KIRKLEES METROPOLITAN COUNCIL INVESTMENT & REGENERATION SERVICE

DELEGATED DECISION TO DETERMINE PLANNING APPLICATIONS

Reference No:	2026/62/90539/W
Site Address:	adj, 106, New Street, Huddersfield, HD1 2UD
Description:	Installation of 1 BT Street Hub, incorporating 2 digital 75inch LCD advert screen and associated BT Phone Kiosk removal (within a Conservation Area)
Recommending Officer:	John Holmes

DECISION – Refused

Drawing Title  
**EXISTING AND PROPOSED ELEVATIONS**

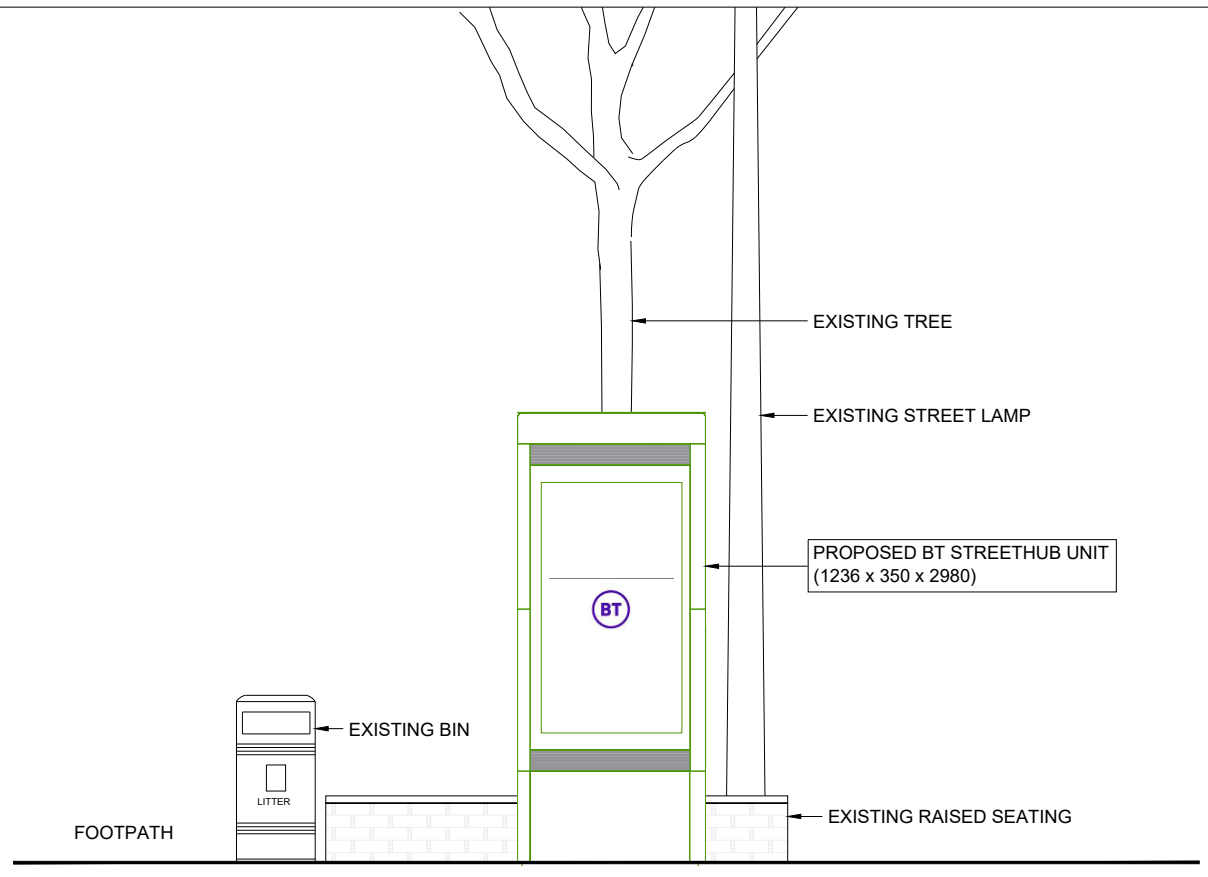
The removal of a single phone box would be a modest enhancement to the Conservation Area and the wider Town Centre. However, the introduction of a further 3m high structure featuring a pair of display panels would add further illuminated street clutter which would, especially in the context of already existing digital display screens, detract from the character of the area and cause cumulative harm. It would thereby conflict with both Huddersfield Blueprint initiatives mentioned above and the aims of Policies LP17(a), LP24(a) and LP35, and also those of Chapter 16 of the NPPF, and the Council's duty under section 72 of the Planning (Listed Buildings and Conservation Areas) Act 1990, which states that Local Planning Authorities shall pay special attention to the desirability of preserving or enhancing the appearance of buildings or land within a Conservation Area. It would also be contrary to Planning Practice Guidance on advertisements which sets out the 'amenity' issues includes the local characteristics of the neighbourhood and historic features.

The proposed Street Hub would support digital display screens on both sides. These are an integral part of the development under consideration, as set out in paragraph 2.2 of the Planning Supporting Statement. The proposed Street Hub and digital display screens, owing to their scale, prominent siting, means of illumination and the presence of other similar installations in the immediate vicinity, would be a visually intrusive feature that would cause harm to the
